from
**Southern
Water**

Our ref
DSA000005825

Proposal: Approval of reserved matters following outline consent LU/47/11/ (amended under LU/182/15/PL) for the main on-site infrastructure at Hampton Park and encompasses: 1) the Central Wetland Area, 2) the main spine road and crossing structures & 3) the SUDs features.

Site: LU/369/21/RES: - Central Wetland Area, Hampton Park, Toddington Lane, Littlehampton, BN17 7PL.

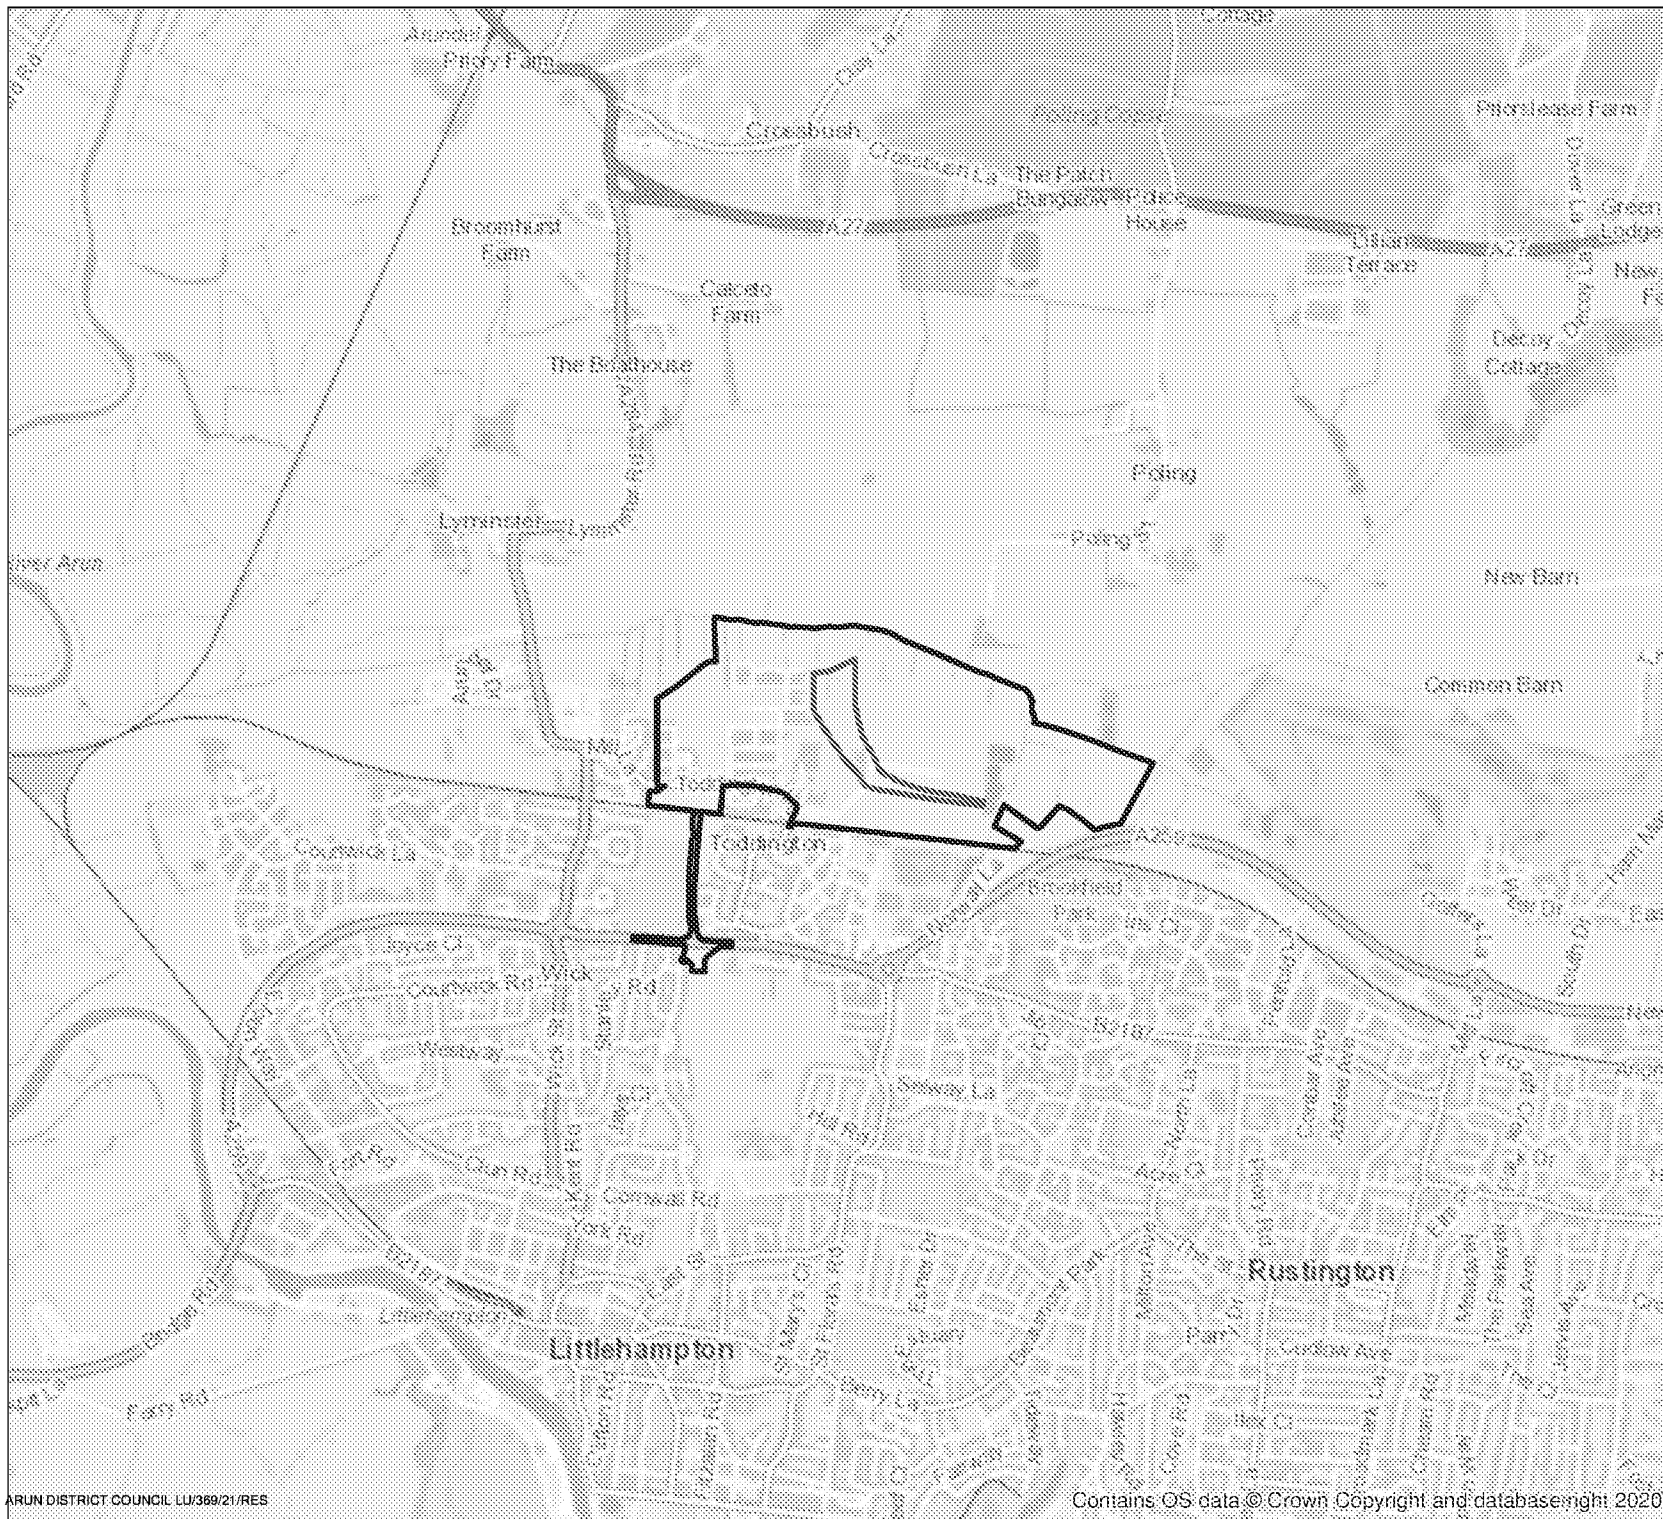
The submitted surface water drainage layout and landscape plan indicates proposed tree planting, swale, ponds, or any other surface water retaining or conveying features close to the public trunk main which is not acceptable to Southern Water.

- The 9 inches, 14 inches public water trunk mains require a clearance of 6 metres on either side of the trunk mains to protect it from construction works and to allow for future access for maintenance.
- No excavation, mounding or tree planting should be carried out within 6 metres of the external edge of the public water trunk mains without consent from Southern Water.
- No soakaway, swales, ponds, watercourses or any other surface water retaining or conveying features should be located within 5 metres of a public sewer.
- All existing infrastructure, including protective coatings and cathodic protection, should be protected during the course of construction works.

We have restrictions on the proposed tree planting adjacent to Southern Water sewers, rising mains or water mains and any such proposed assets in the vicinity of existing planting. Reference should be made to Southern Water's publication "A Guide to Tree Planting near water Mains and Sewers" ([southernwater.co.uk/media/3027/ds-tree-planting-guide.pdf](https://www.southernwater.co.uk/media/3027/ds-tree-planting-guide.pdf)) and the Sewerage Sector Guidance ([water.org.uk/sewerage-sector-guidance-approved-documents](https://www.water.org.uk/sewerage-sector-guidance-approved-documents)) with regards to any landscaping proposals and our restrictions and maintenance of tree planting adjacent to sewers, rising mains and water mains.
